From: Lauren Willard [REDACTED]
Sent: 16 February 2022 14:02
To: Kathryn Welch <Kathryn.Welch@arun.gov.uk>
Subject: EP/172/21/PL

Drawing Title:
Topographical Plans

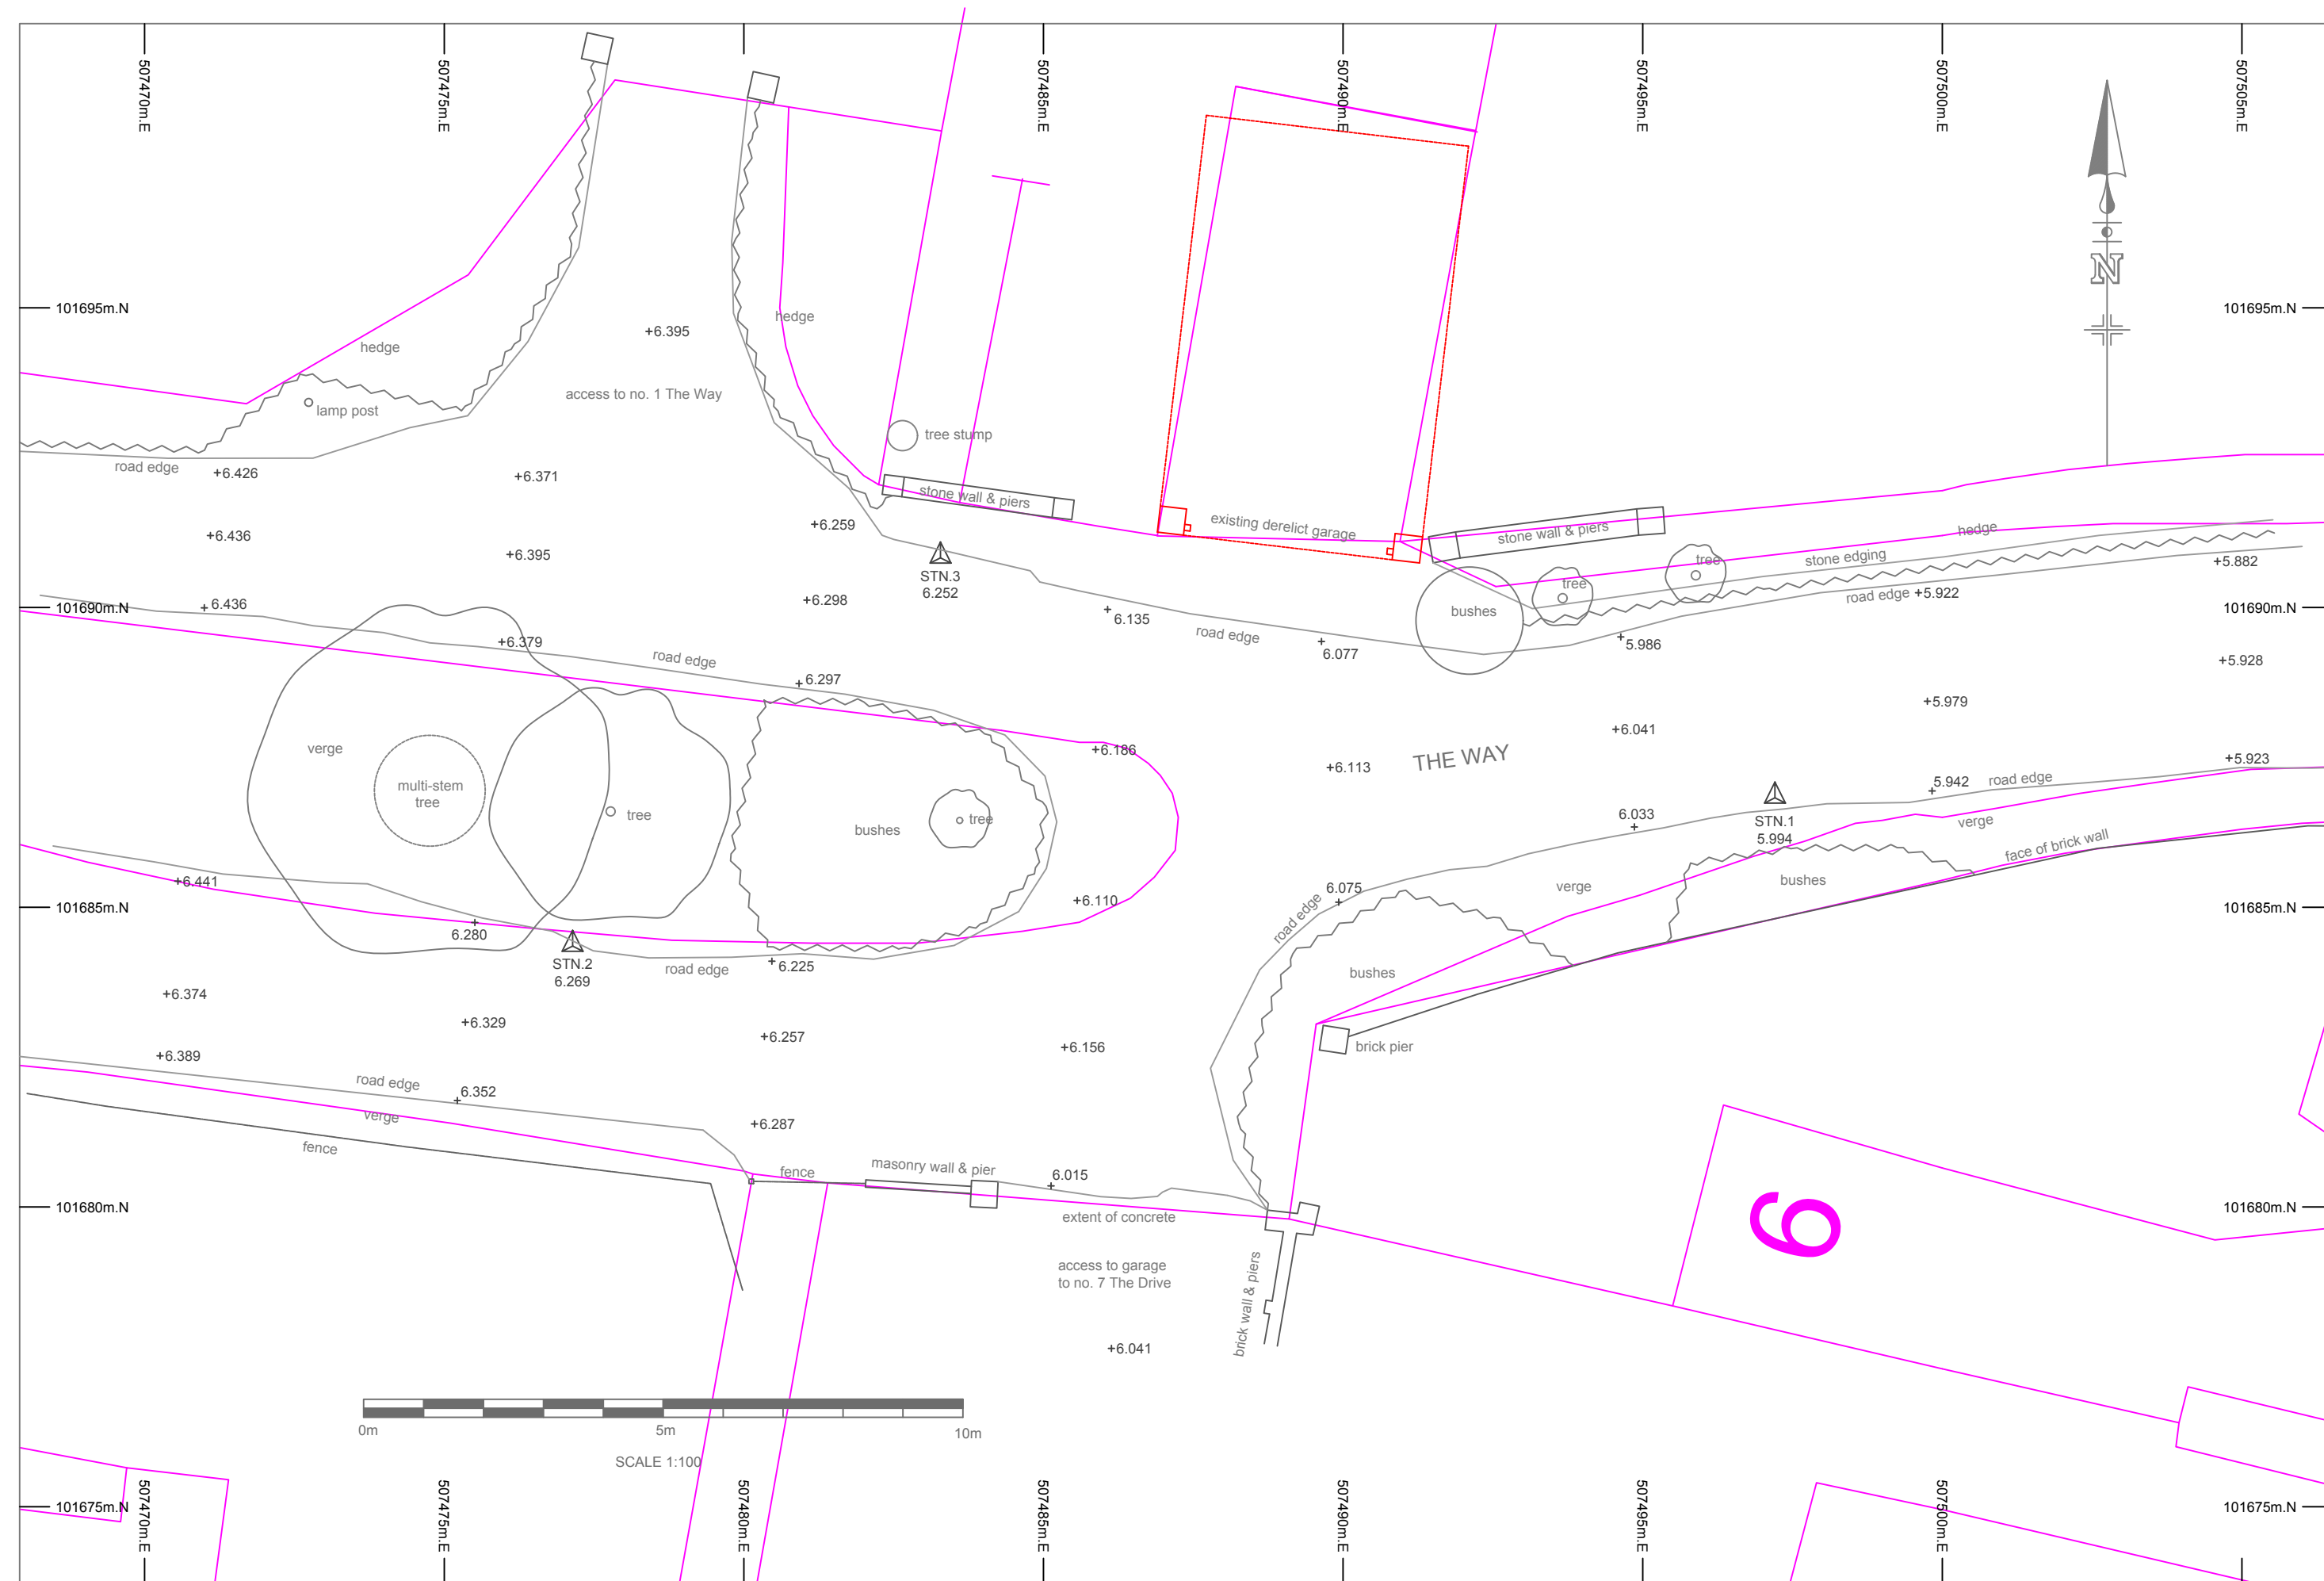
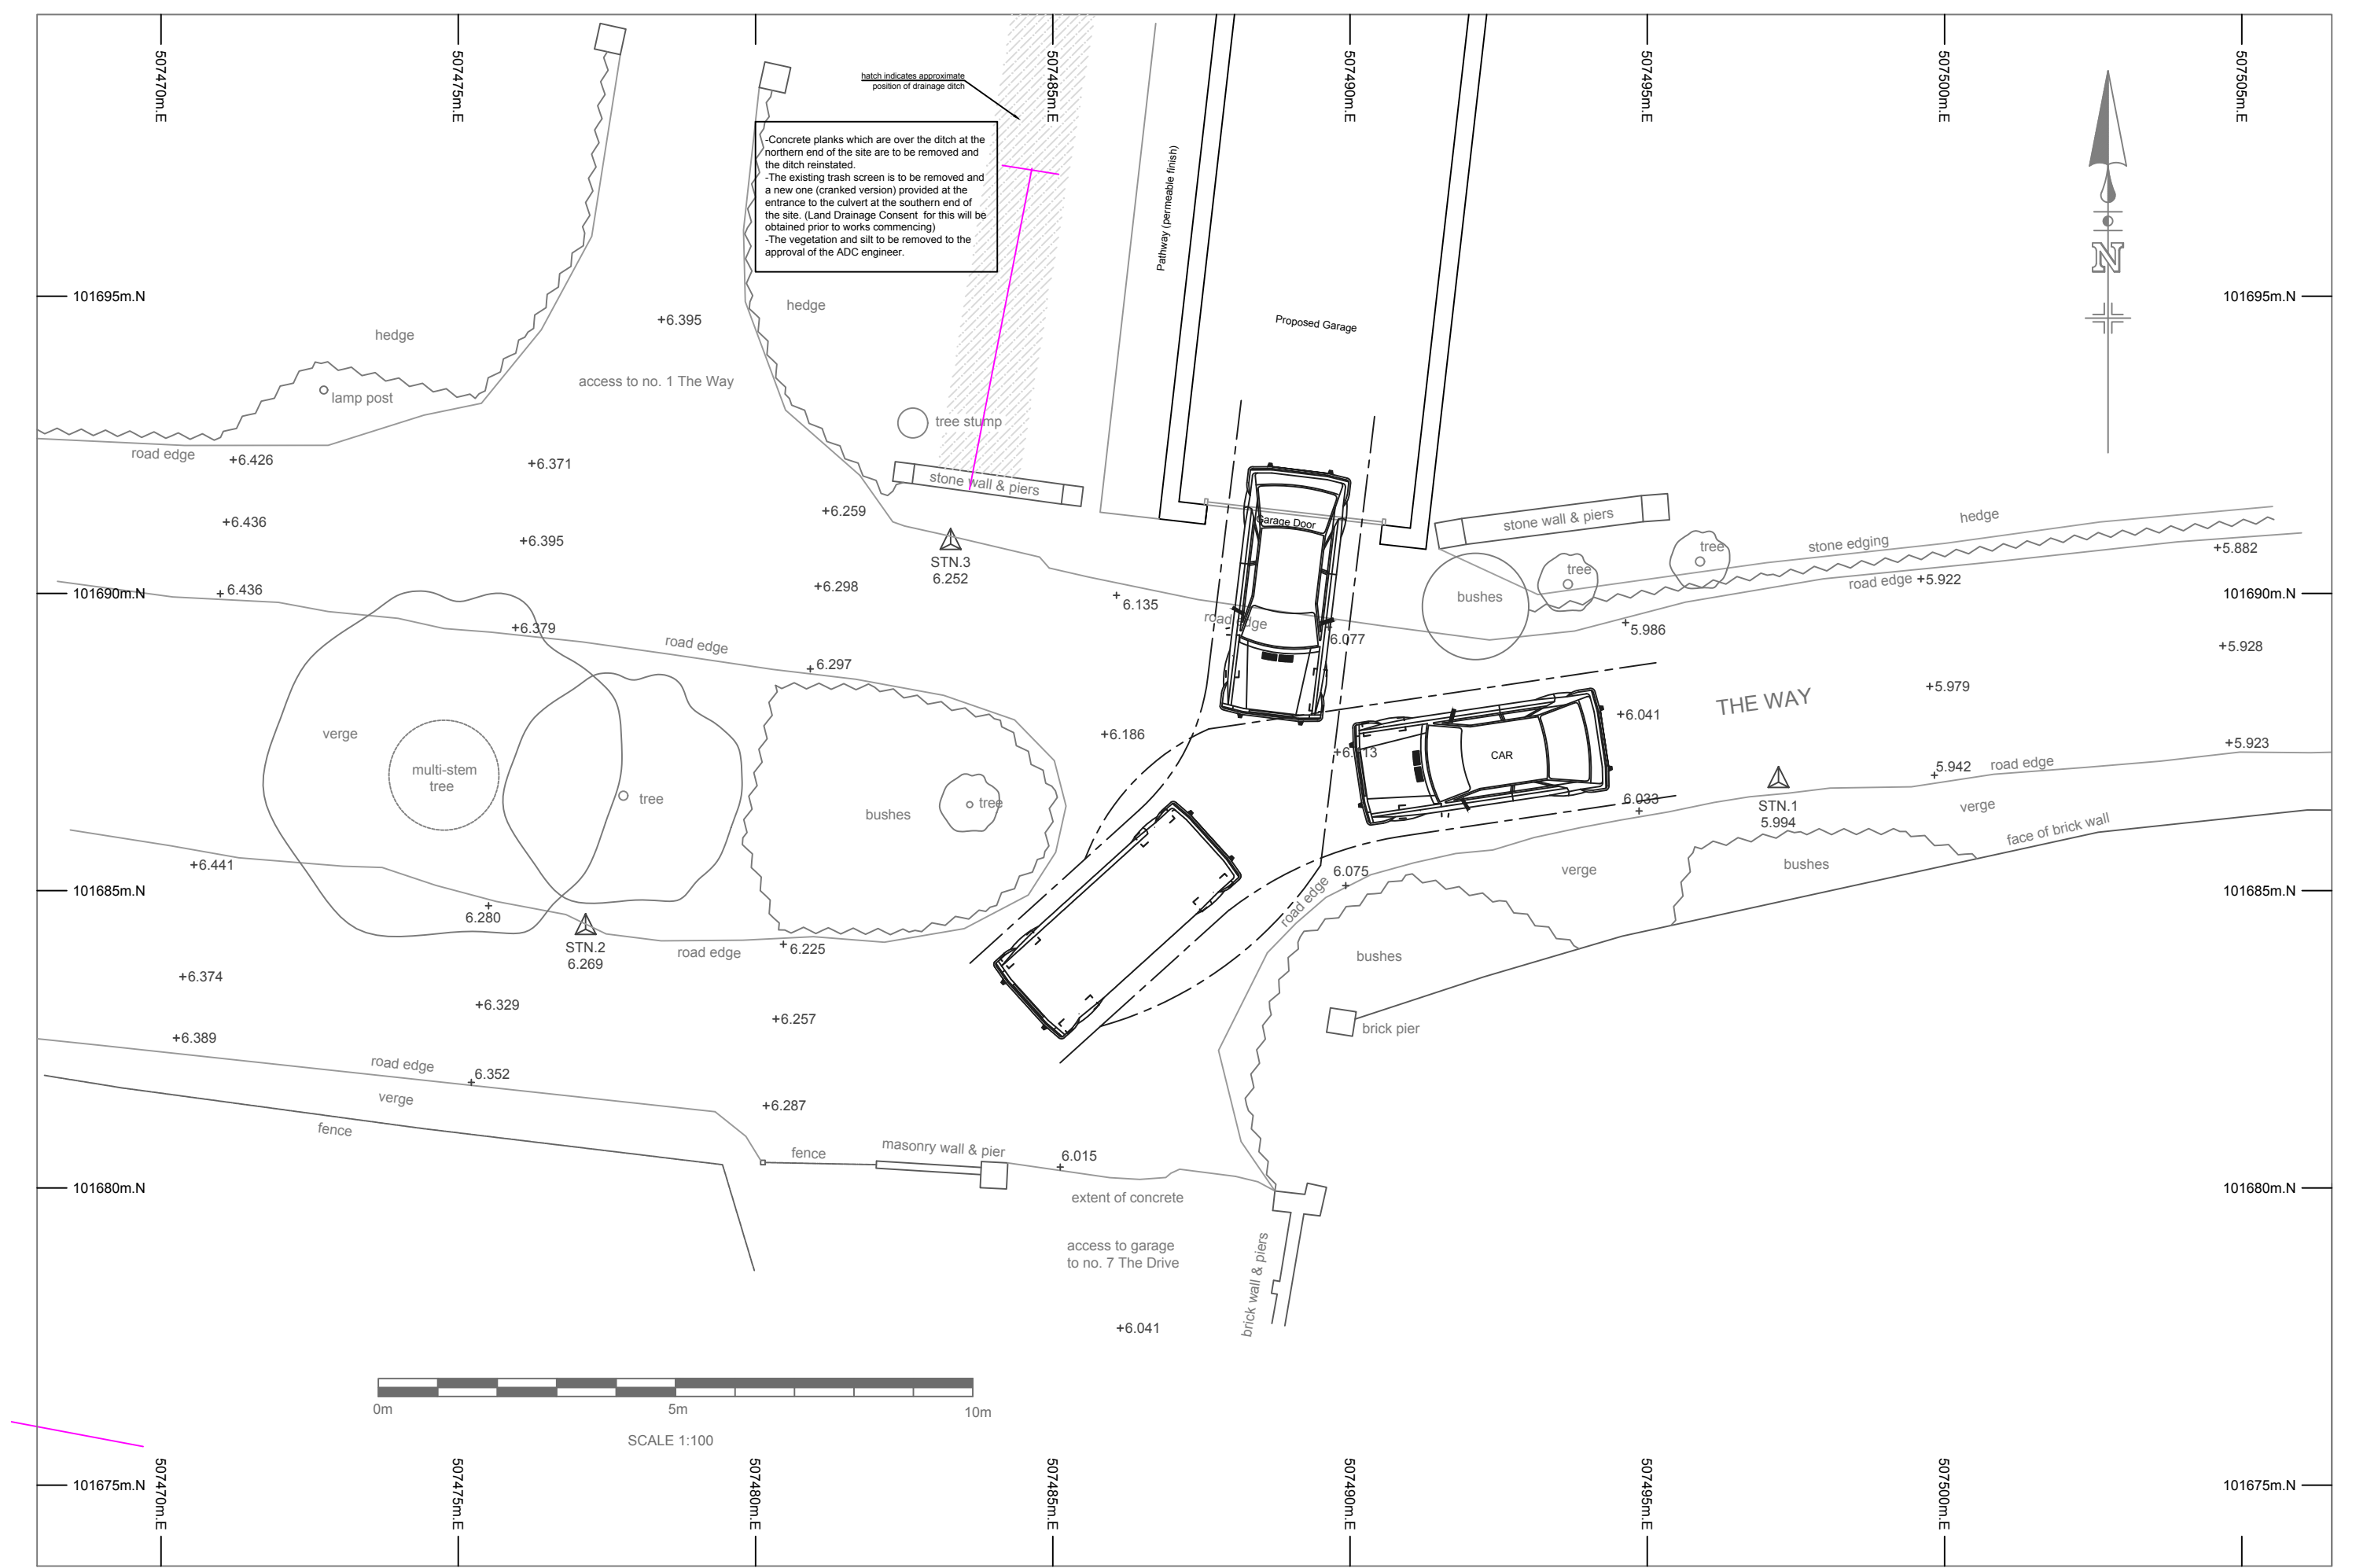
I have spoken with Paul Cann regarding his comments. He has said we will need to apply for Land Drainage consent following approval of the planning Application. The application for Land Drainage Consent will be approved subject to the following being included in the application;

- The concrete planks removed from the northern end of the site which are over the ditch
- The existing trash screen removed and a new one provided at the entrance to the culvert at the southern end of the site.
- The vegetation removed
